Section 4.55(1A) Application to Modify development Consent SSD 9912

Roseville College

27-29 and 37 Bancroft Avenue Roseville

Council's objection in reply to the S 4.55 (1A) application

Figure 7 | Proposed modifications to the landscape plan (Source: Applicant's additional information 2022)

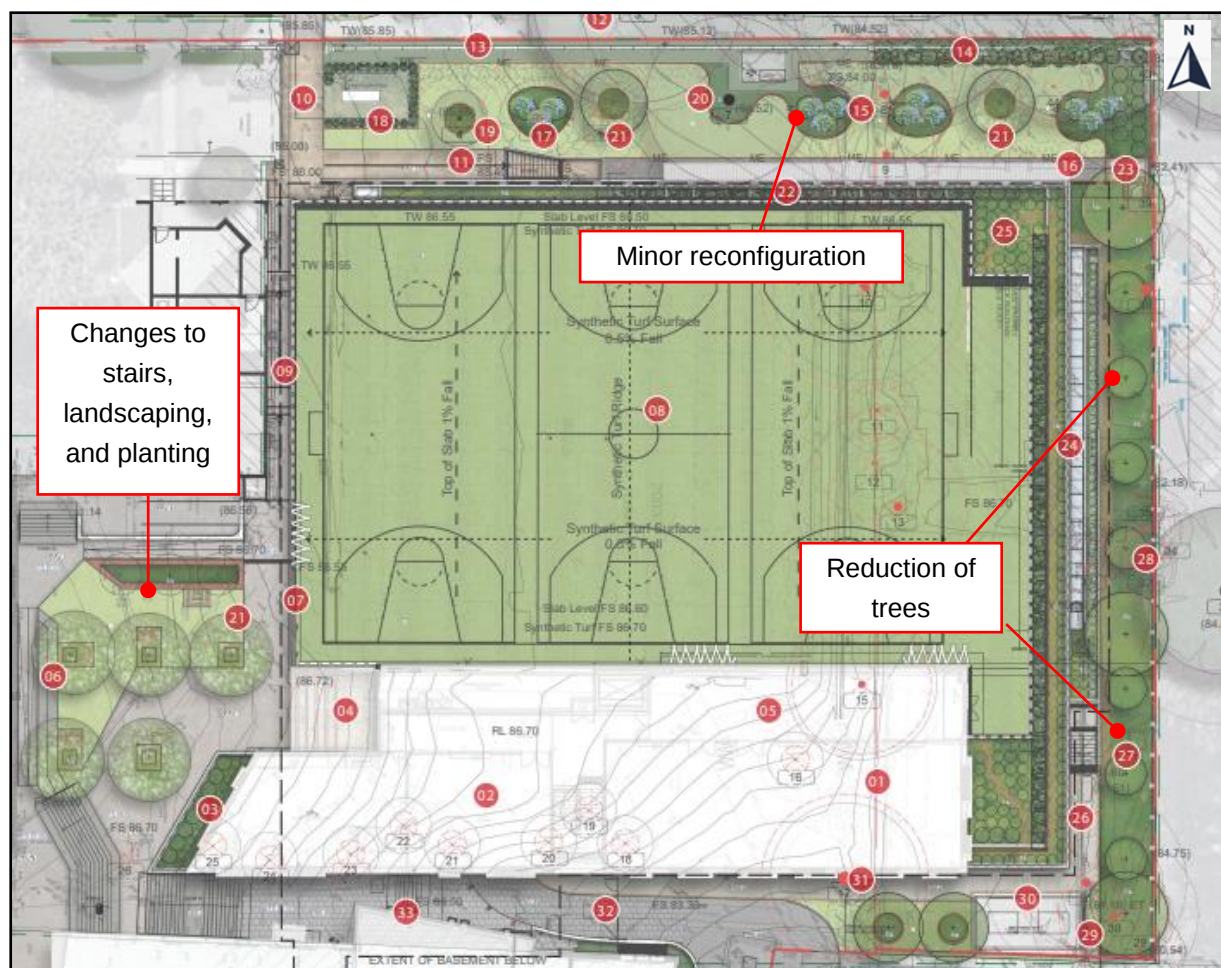
- The plans indicate an option between an evergreen shrub Port Wine Magnolia/*Michelia figo* capable of attaining a height up to approximately 3.0m high (although usually maintained at approx. 2.0m or less) and a small deciduous tree that grows between 5.0-8.0m high. Council's preference would be for to be planted along the length of the eastern boundary. The shrub planting would provide amenity and screening at eye level, while the small tree planting would provide partial and seasonal screening of the upper levels of the building. The architectural sections and elevations submitted with the application would indicate the planting of small trees. With intensification of a site's usage, it is the objective of Council's DCP to ensure that new buildings sit within a dominant soft landscape setting with the provision of trees in all setback areas. The

planting of both small trees and shrubs within the 'side' setback would satisfy this objective and the broader aims of the DCP.

- The planting of only 7 shrub plantings within the eastern setback (as depicted on plan) is insufficient to sufficiently screen and soften the built form, and is therefore inconsistent with the DCP Aims, Objectives and Controls for screen and amenity planting, particularly within an HCA.
- The proposed species selection is appropriate for the HCA.

- The inclusion of 'island' garden beds within a lawn area is uncharacteristic of the established landscape setting within the HCA. It is Council's preference for the island planting to be incorporated as part of a curved mixed shrub border across the site frontage with specimen/feature trees within the lawn expanse. This design outcome would be consistent with the established landscape character within Bancroft Ave.
- The inclusion of a mixed shrub border reduces ongoing maintenance, through easier management of the lawn area.
- The species selection is appropriate for the HCA.
